RE: Trails at Aspen Ridge -- (PUDSP-21-003)

This is to inform you that the above-reference request for approval of a map amendment (rezoning) from an overall zoning and conceptual PUD (Planned Unit Development) to a site specific PUD (Planned Unit Development) to develop 75 single-family residential lots, rights-of-way, and open space within a 117.98-acre development area was heard by El Paso County Board of County Commissioners on June 1, 2021, at which time an approval was made. (Parcel Nos. 55093-02-003 and 55093-05-003)

SP02

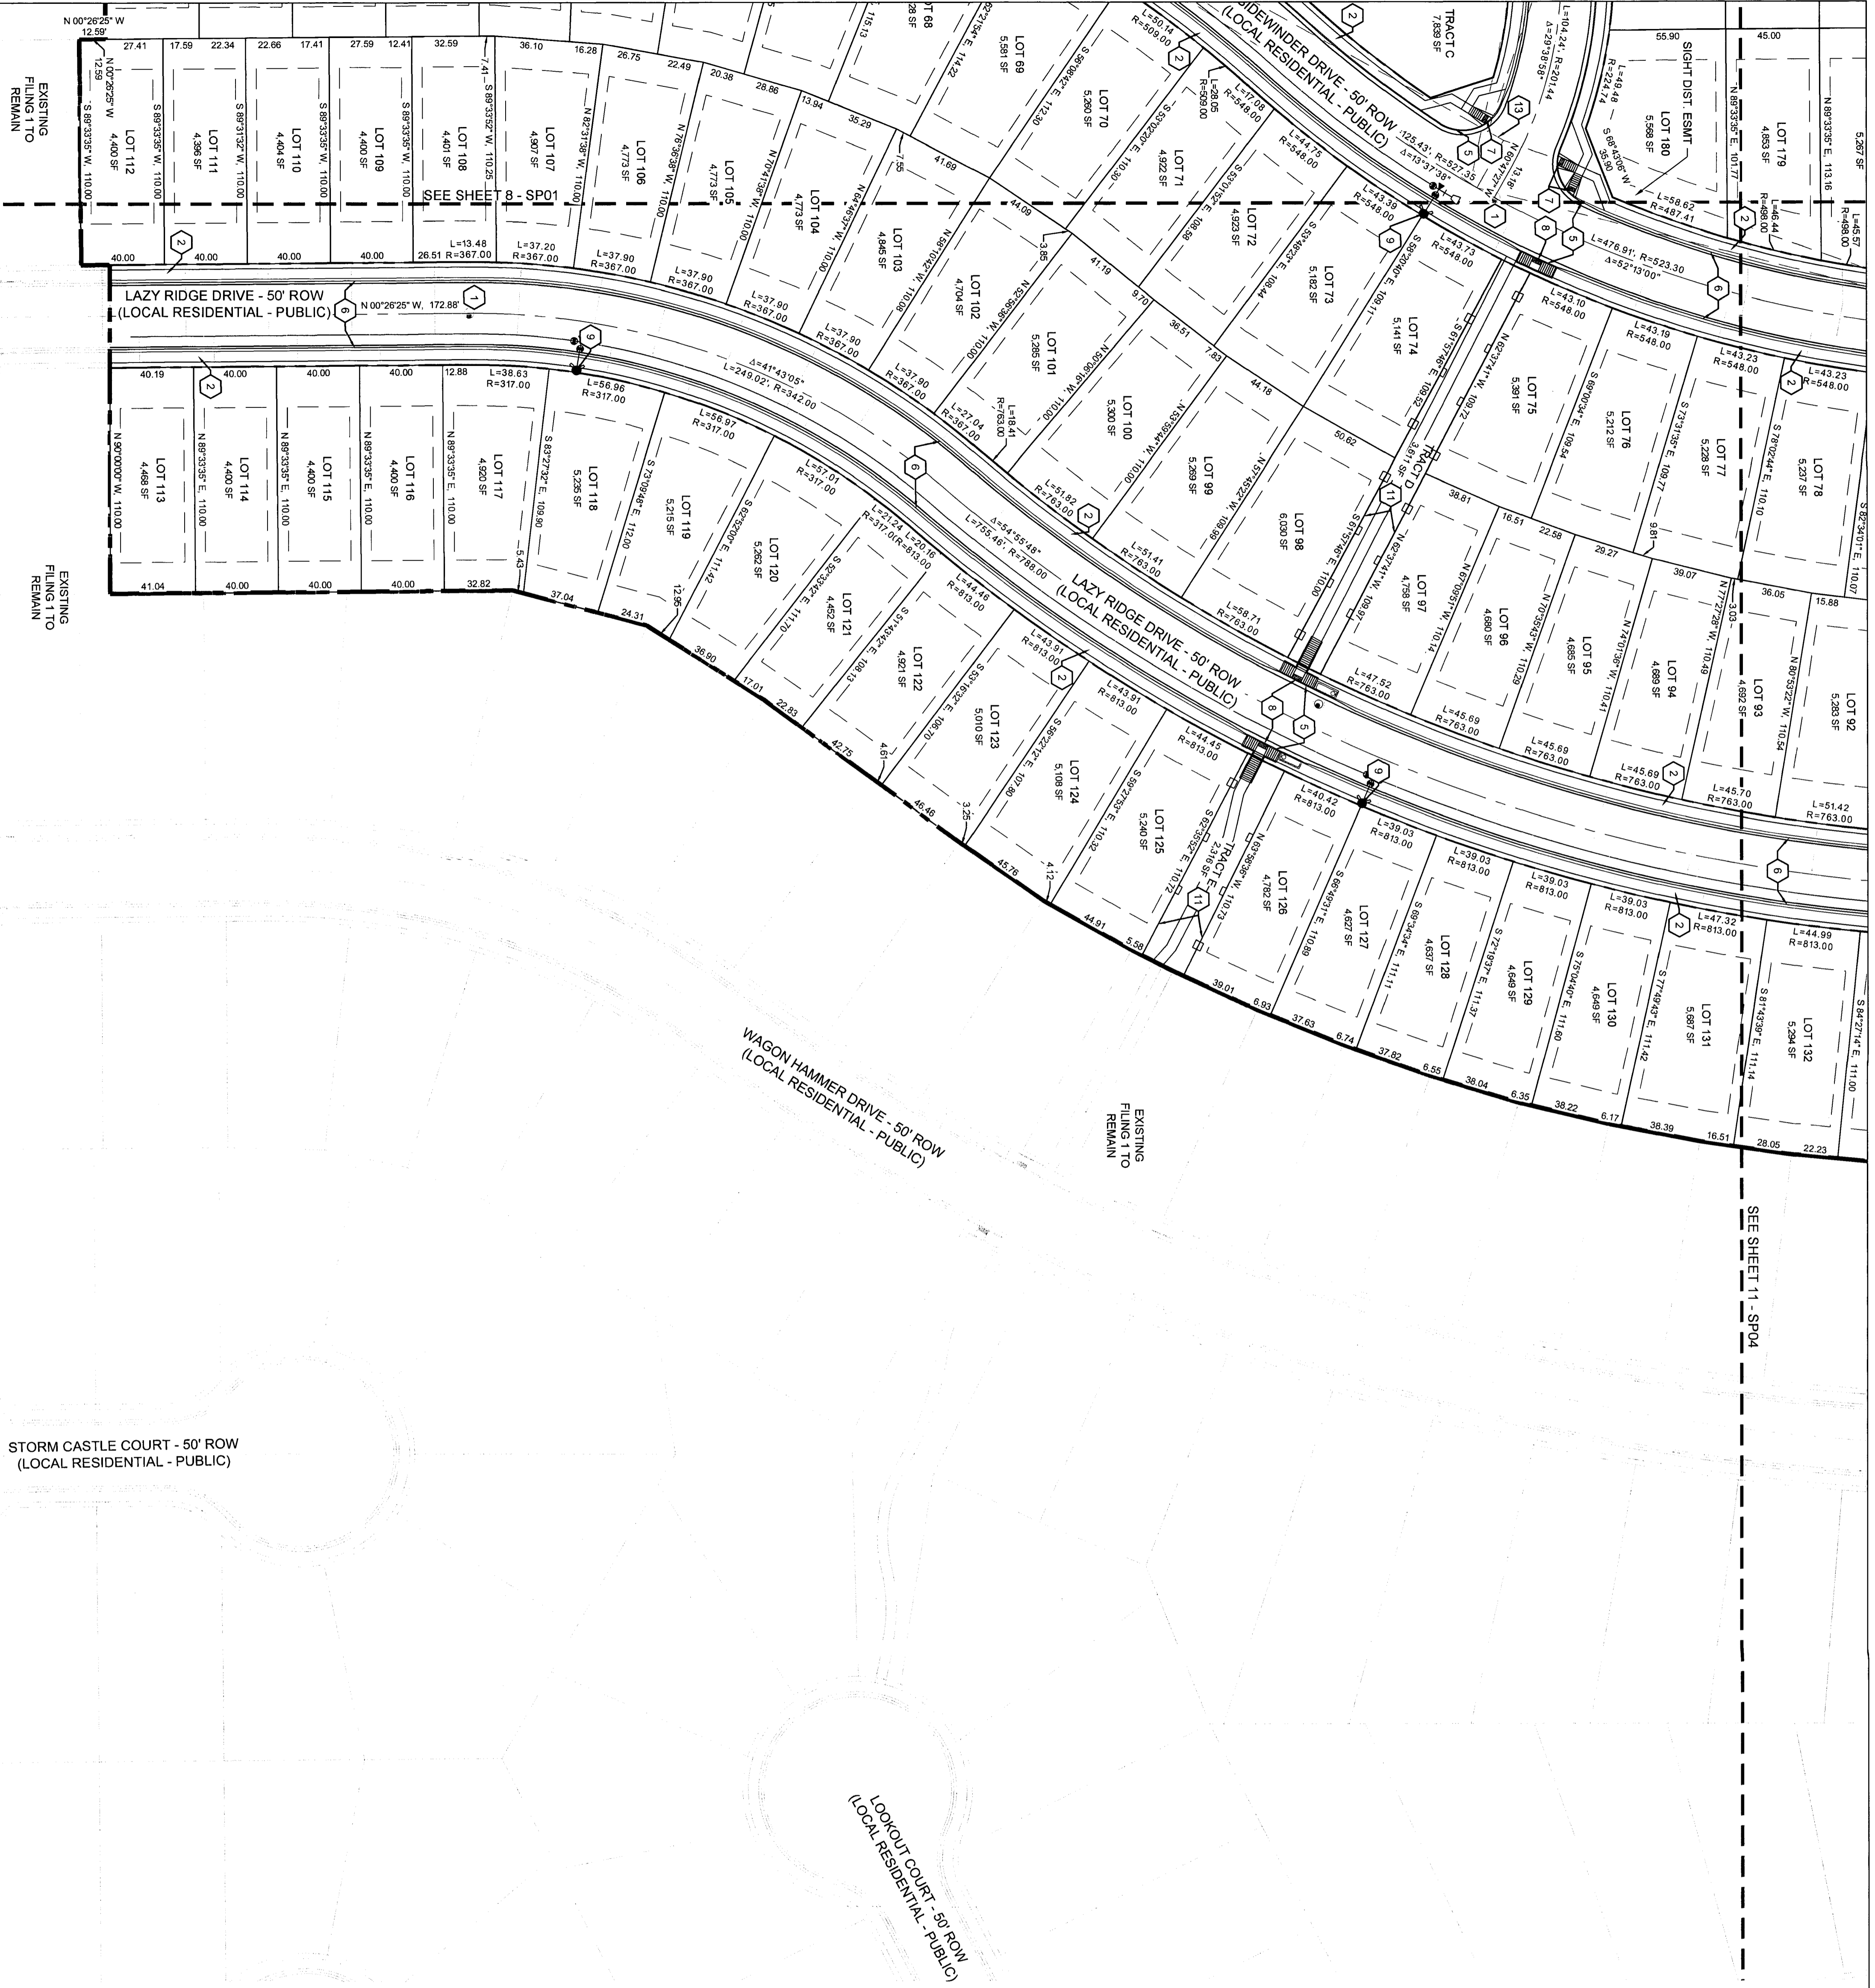
2. A PUD modification of Section 2.5.2.C.4 of the ECM to omit midblock pedestrian crossings along Blue Miner Street, Lazy Ridge Drive, and Wagon Hammer Drive.

“Access ramps on local roadways shall be spaced no greater than 600 feet apart. Where spacing is greater than 600 feet, mid-block access ramps shall be provided at spacing that minimize travel distances between access ramps. Private accesses may be used for these access points where the access is designed to meet access ramp requirements.”

Per the PUD/Preliminary Plan, adequate pedestrian accessibility is provided by access ramps at all intersections and mid-block trail crossings. Additionally, the Federal Americans with Disabilities Act (ADA) has no requirements for maximum distance between pedestrian crossings that would necessitate additional mid-block pedestrian ramps.
